Welwyn Hatfield Borough Council

Site: Ellenbrook Fields, Hatfield Business Park, Hatfield

Proposal: Outline application for large scale mixed use development including 1,100 new homes

Application number: 6/2018/2768/OUTLINE

1.9 The Warwickshire, Coventry & Solihull Biodiversity Calculator yields the following key results:

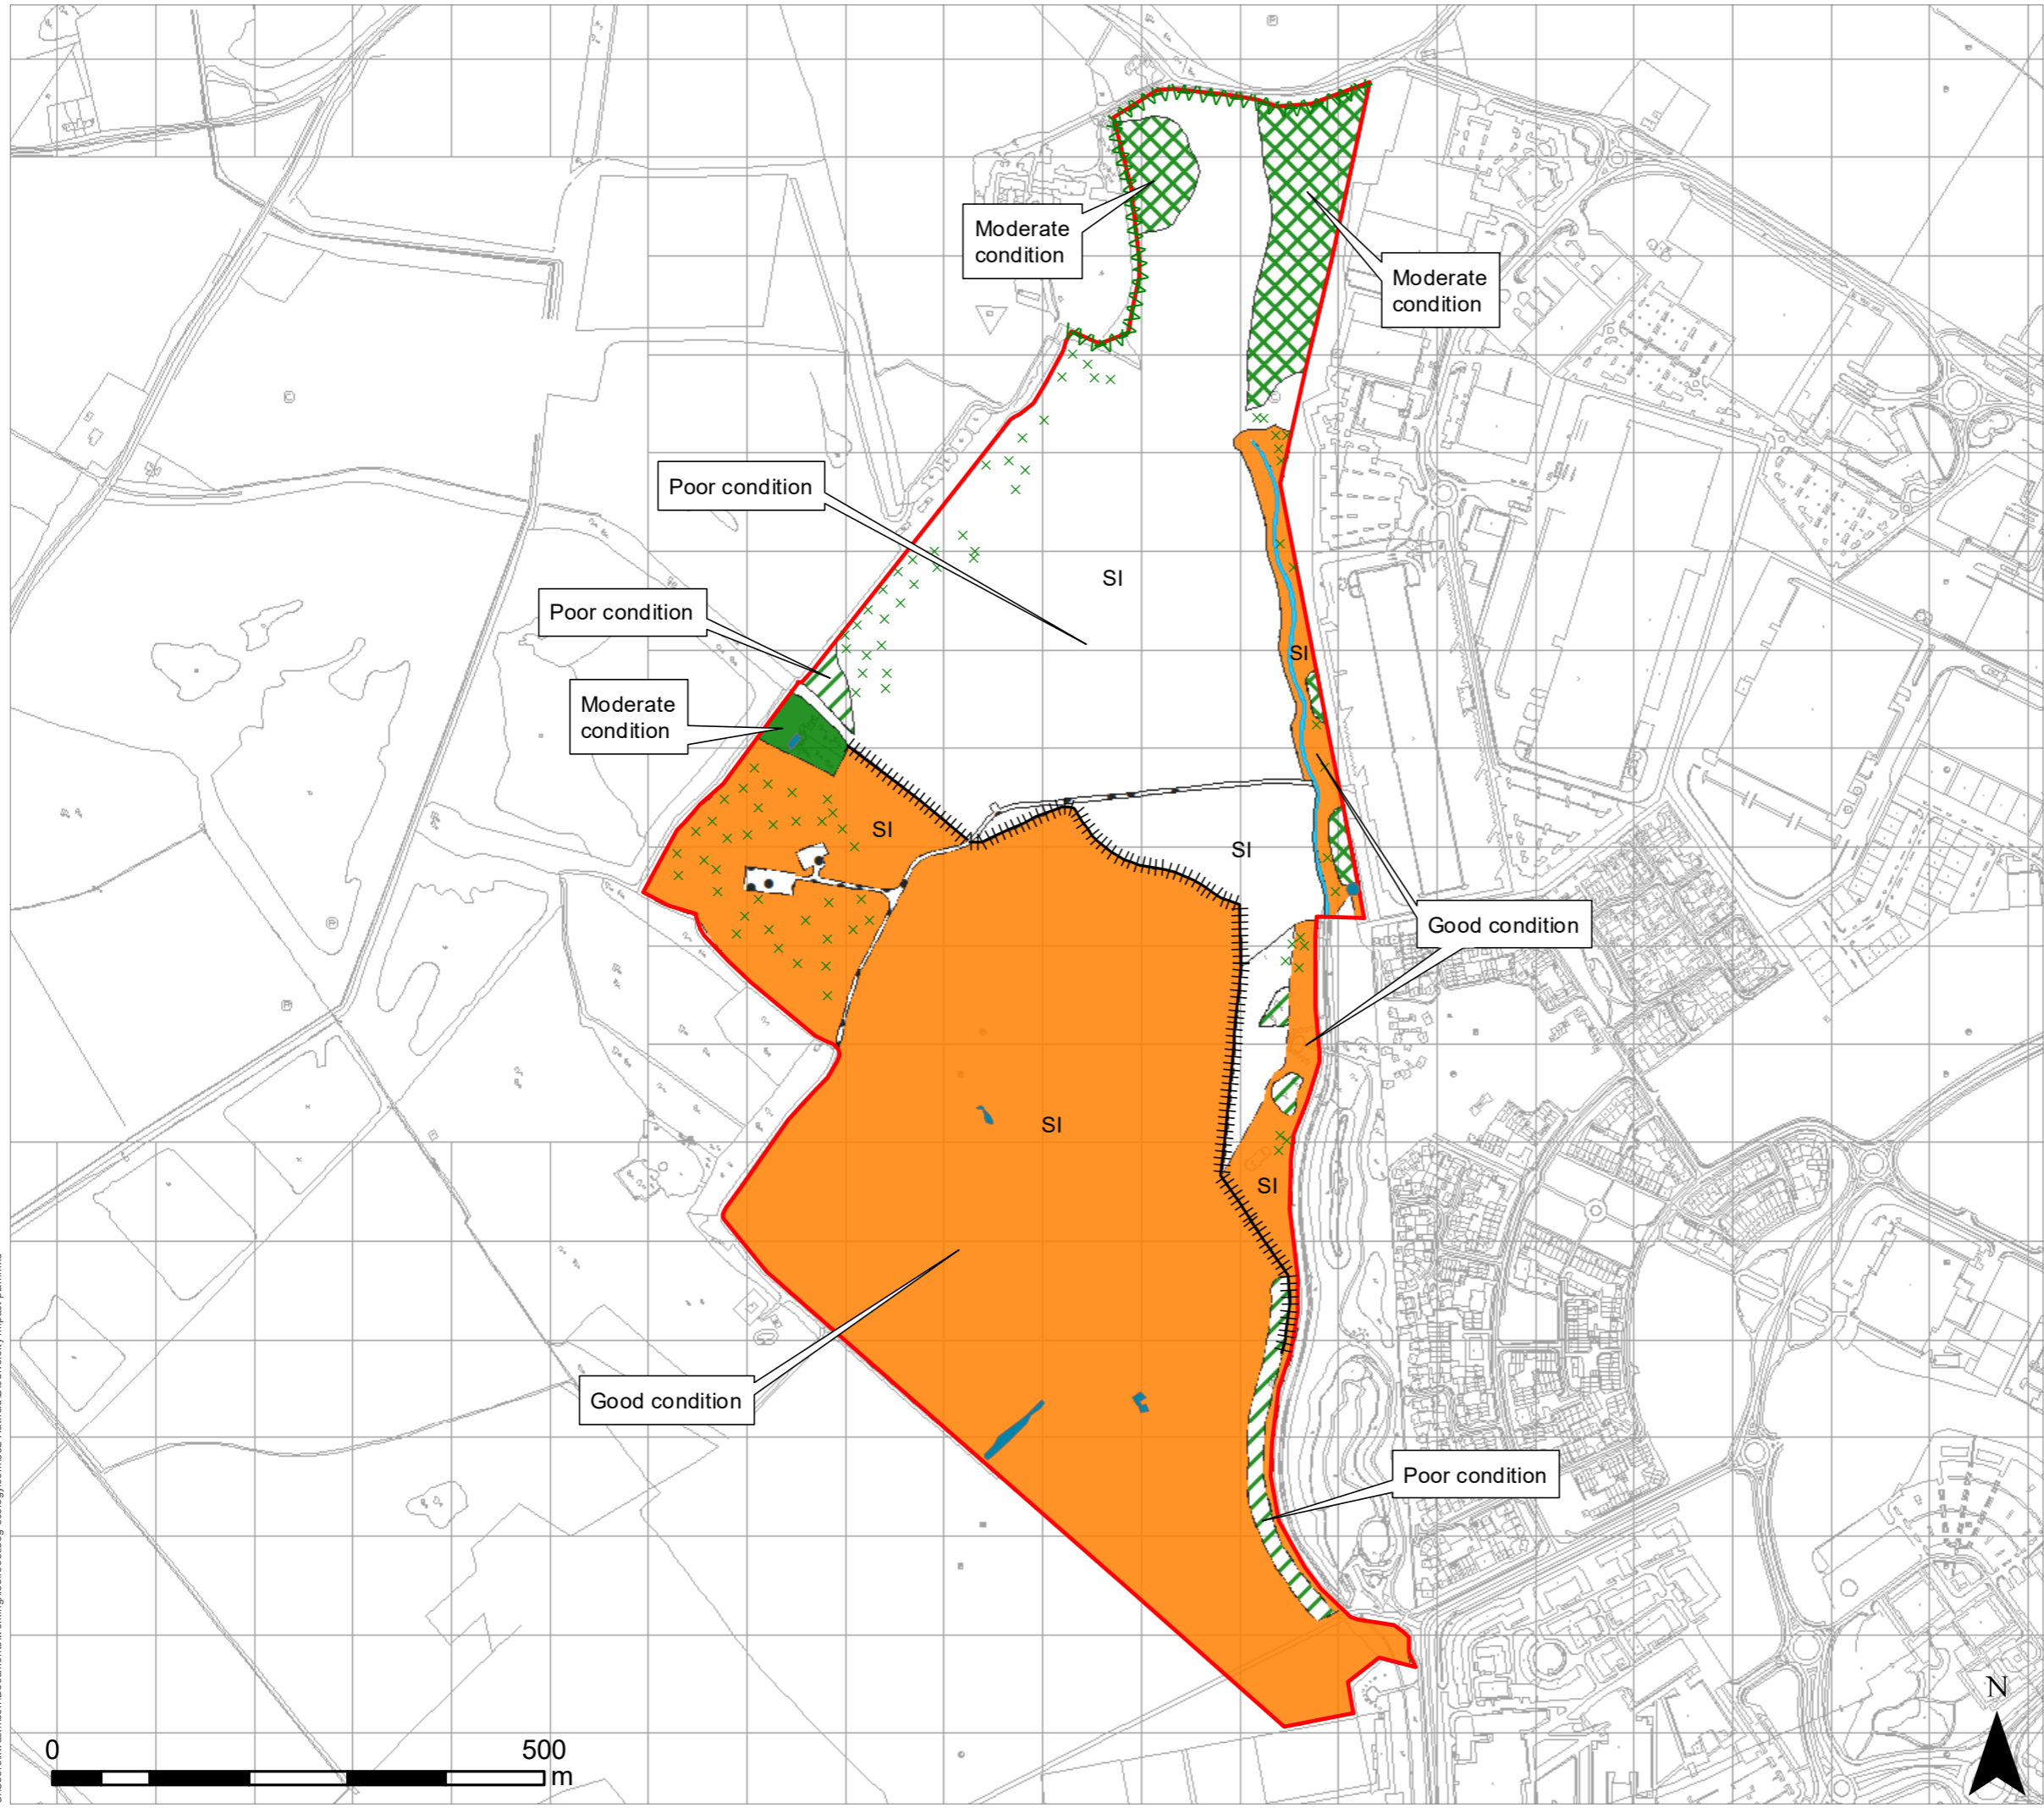
This submission is in relation to the biodiversity impact assessment (BIA) summary supplied in August 2020 by BSG ecology. I will not repeat comments made in previous submission 10/12/2020 where not necessary to do so.

In order for a Defra metric calculation to be verified, it must be supplied in full. The submitted assessment is a summary and therefore not valid. No judgements can be made as to the accuracy of the habitat and condition assessment. The full spreadsheet must be supplied with evidenced justification for each line, which relate directly to a map, with land parcel areas listed.

Irrespective of this a huge net loss has been revealed – in contradiction of the original report. NPPF states that development should not be permitted if there is a net loss to biodiversity, as in this case. The BIA report states (1.12) that:
